Aldwick Bay Estate

Planning Applications No. AW/75/21/HH & AW/85/21/HH

SITE PLAN

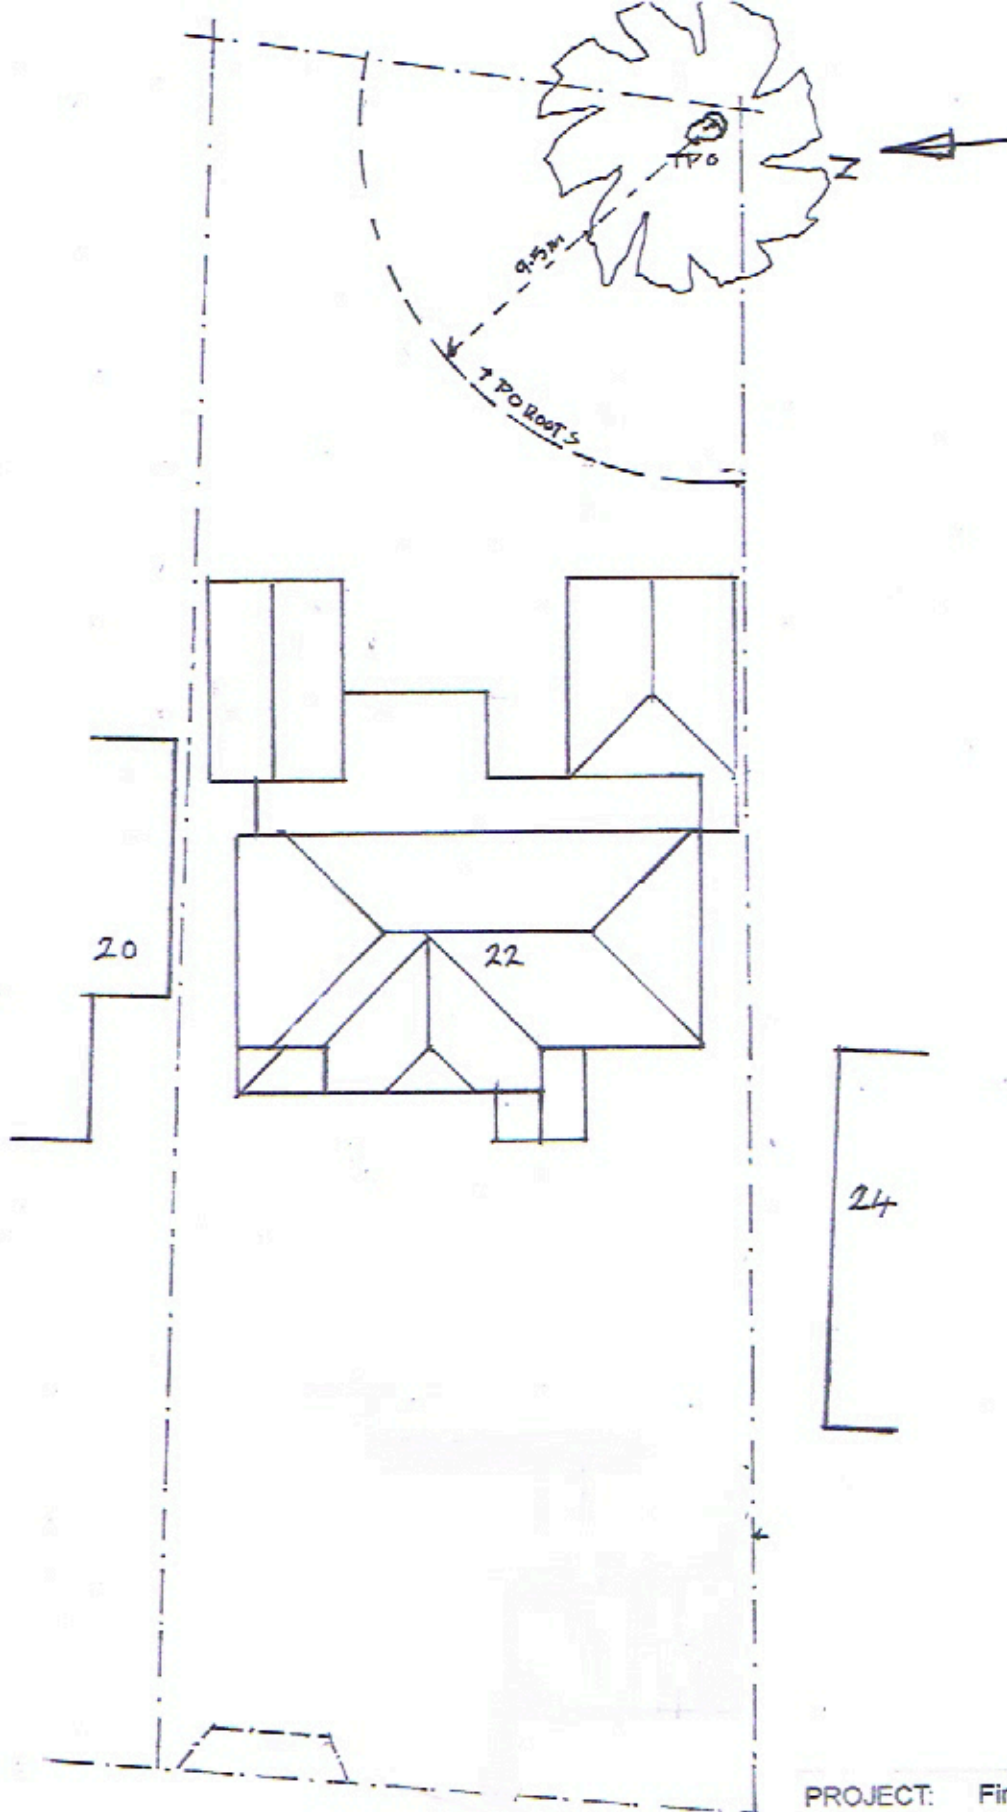
Regarding the application for the first-floor extensions, front detached garage, and rear garden summer house we feel that we could not support the detached front garage in its proposed position as it is forward of the general building line on the east side of A'Beckets Avenue. We feel this would create an unwelcome precedent and would be detrimental to the general street scene. We could only support such a garage if it were no further forward than the house at No24 A'Beckets Avenue.

PROJECT:	Proposed Rear Basement
DRAWING:	Sections and Details SCALE: 1 : 100 & 1 : 50
ADDRESS:	22 A'beckets Avenue Aldwick, Bognor Regis West Sussex PO21 4LX
CLIENT:	Paul Turner TELE: 07704782956

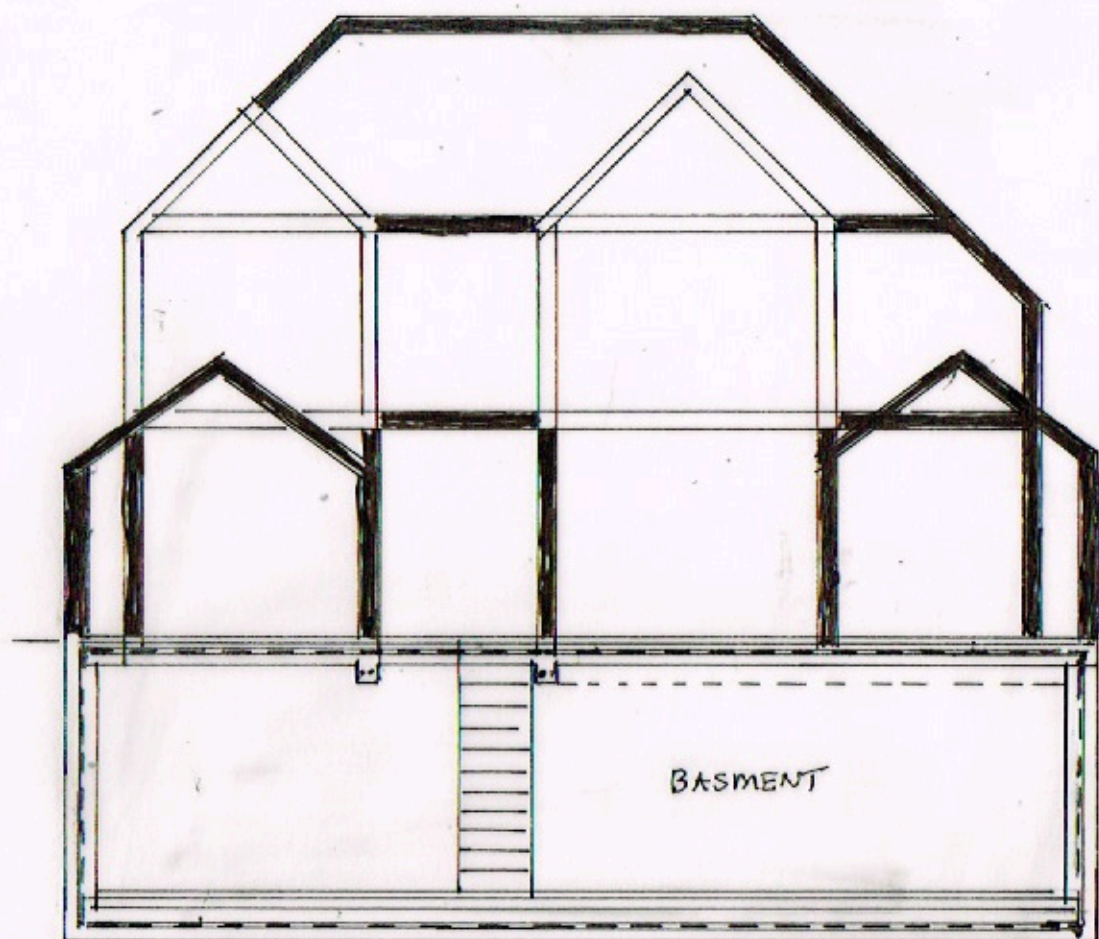
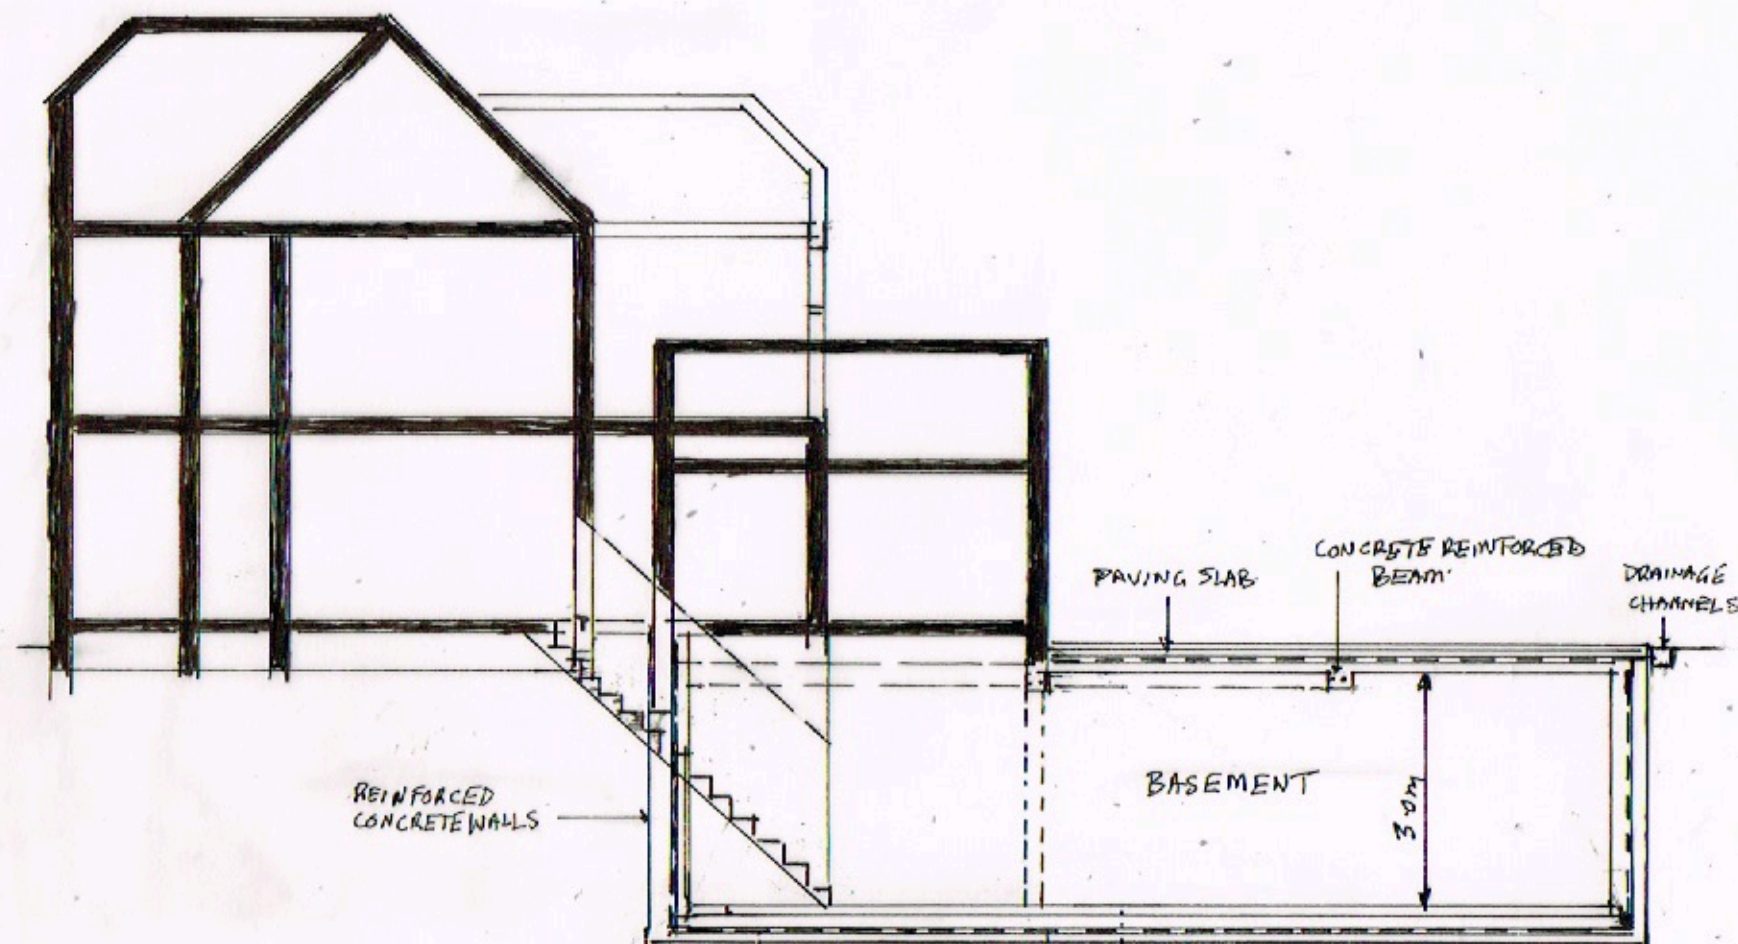
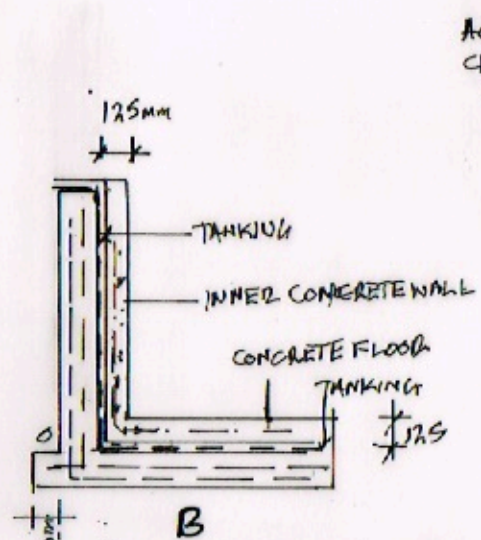
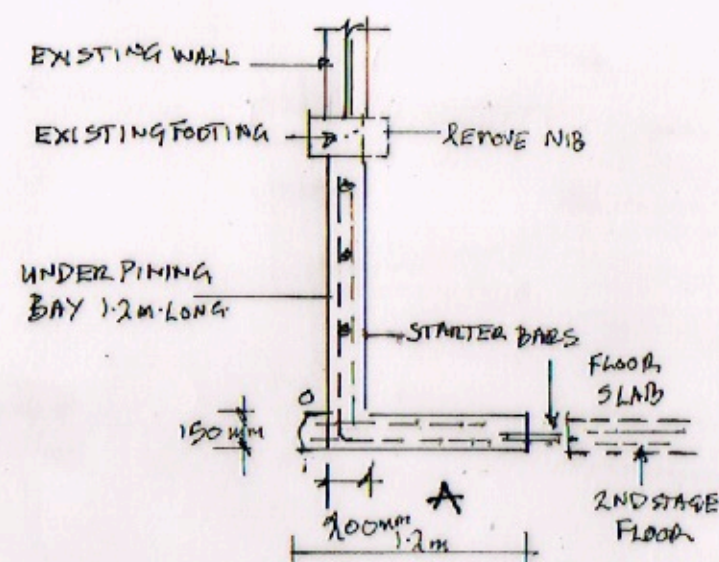
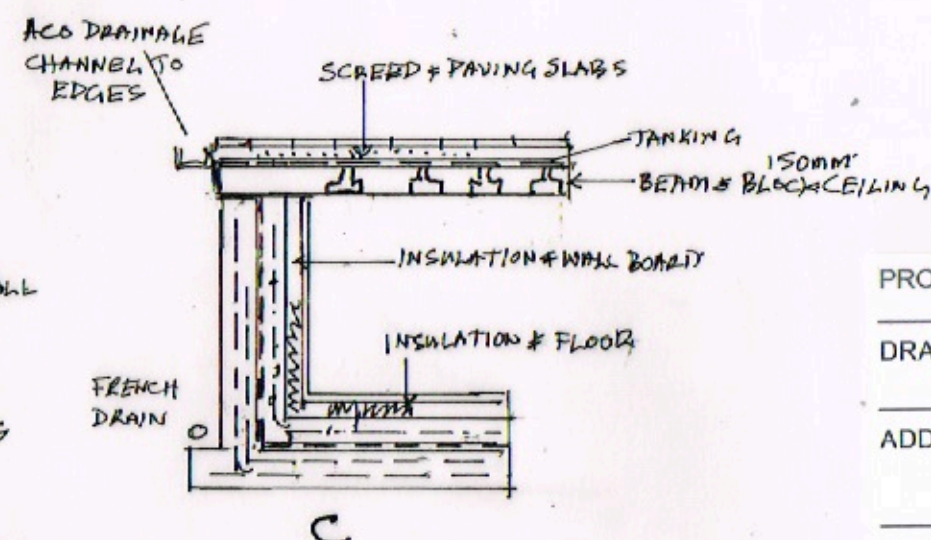
Regarding your proposed rear garden basement, we are unable to support this as such a development might have an adverse effect on neighbours and might give way to flooding, as the water table in and around the Estate is mixed. As you are aware there is no surface drainage in A'Beckets Avenue and the road soak-away drainage often overflows and takes a long time to disburse. There is also a water course along the rear gardens on the east side of A'Beckets Avenue, which continues down West Drive and onwards towards the beach area, and we understand that some of the drainage ditch may have been filled in by residents from both on and off the Estate.

BASEMENT SITE PLAN

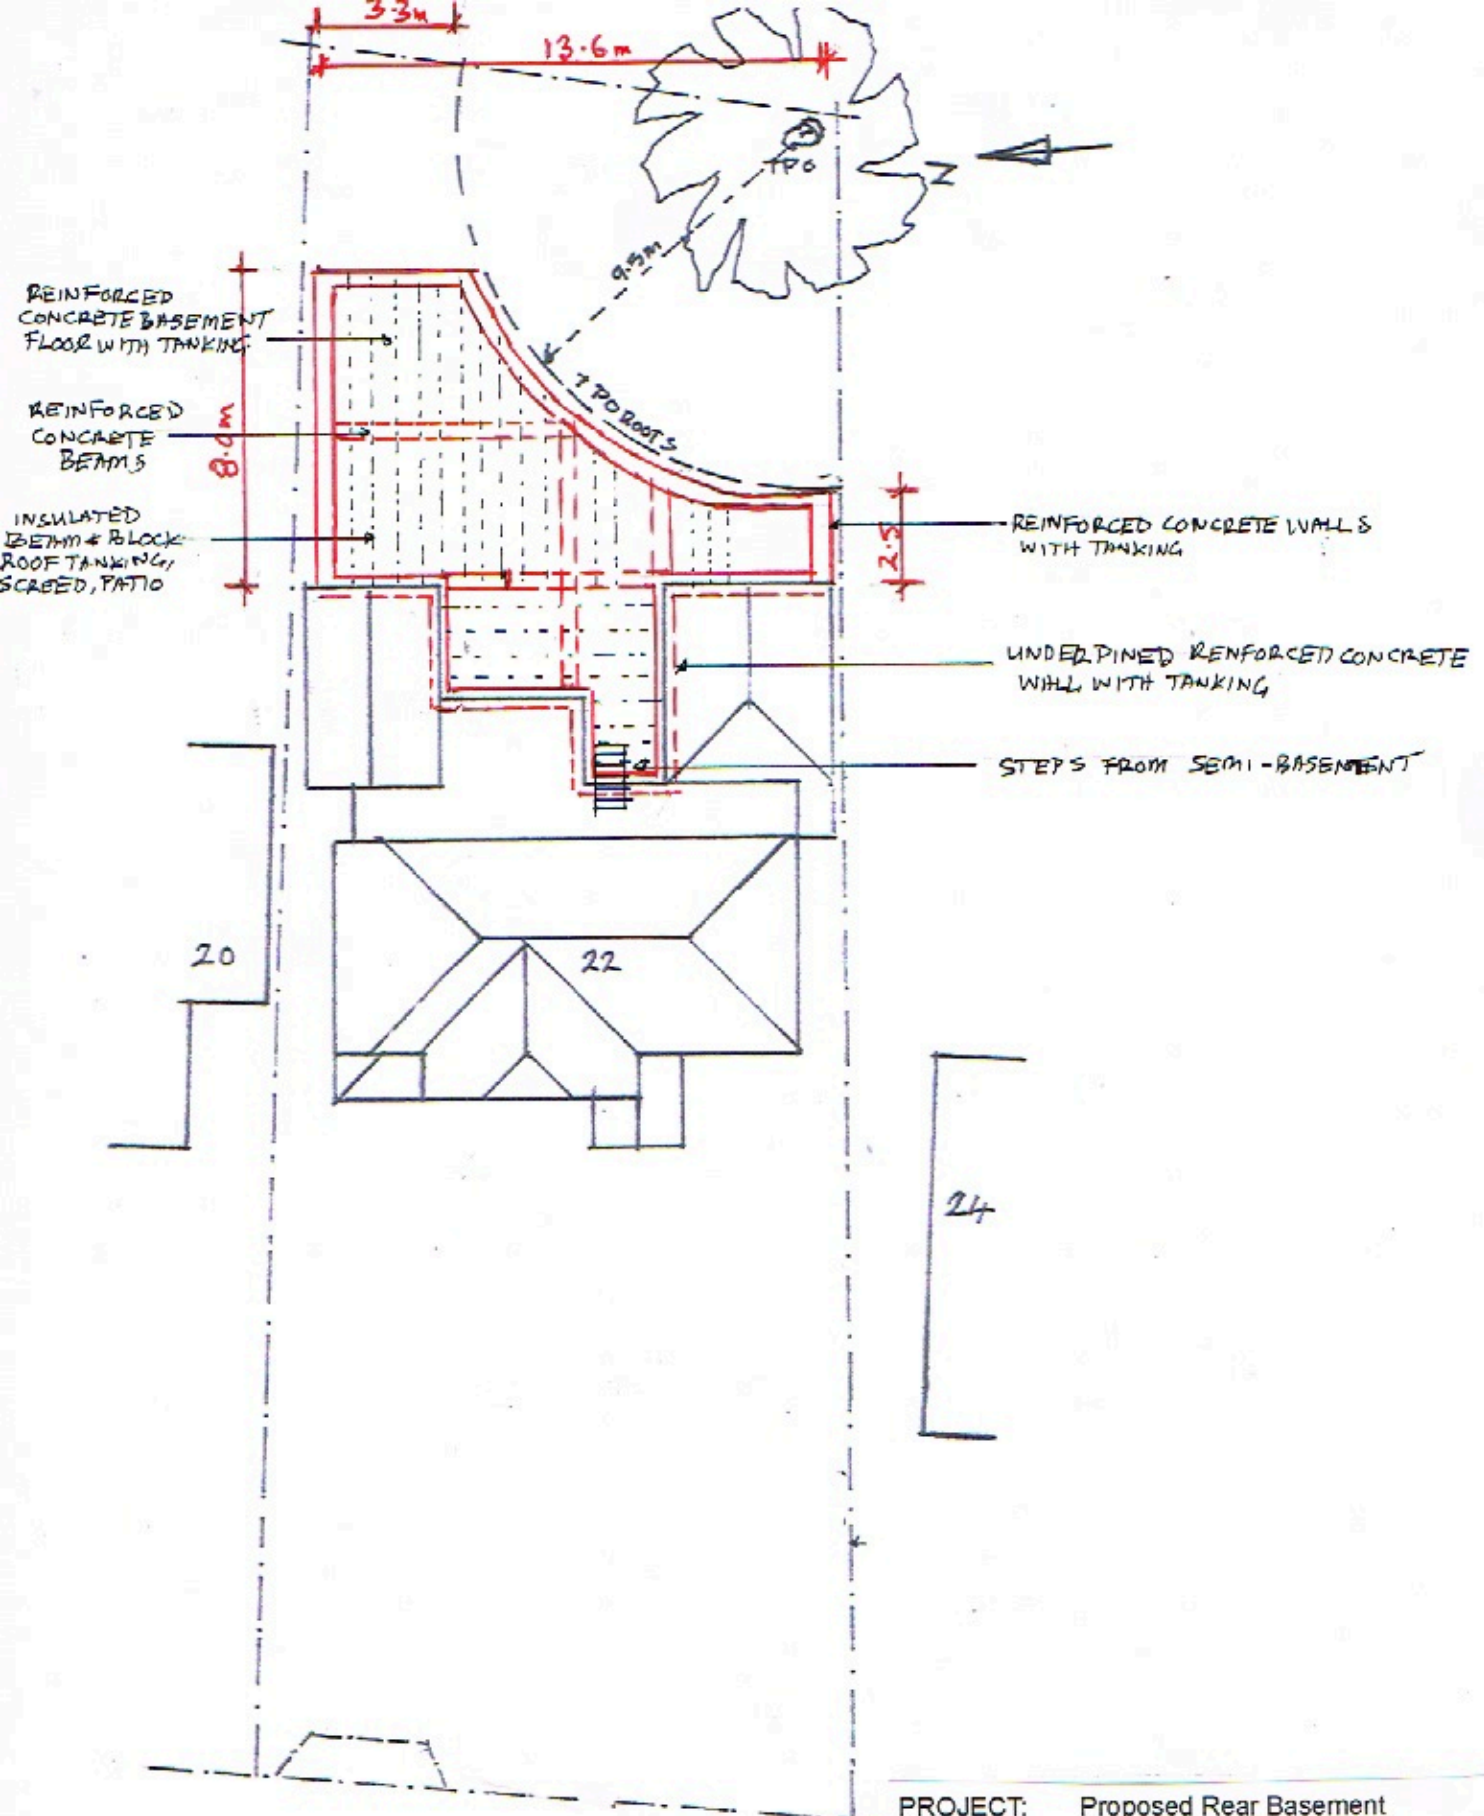
We note that your property does not seem to have any access from the front drive to the rear garden, so we must ask how the work will be achieved, with so much soil being removed and

being replaced by concrete, that alone would be unwelcome to your neighbours and may be to the detriment of anyone using A'Beckets Avenue.
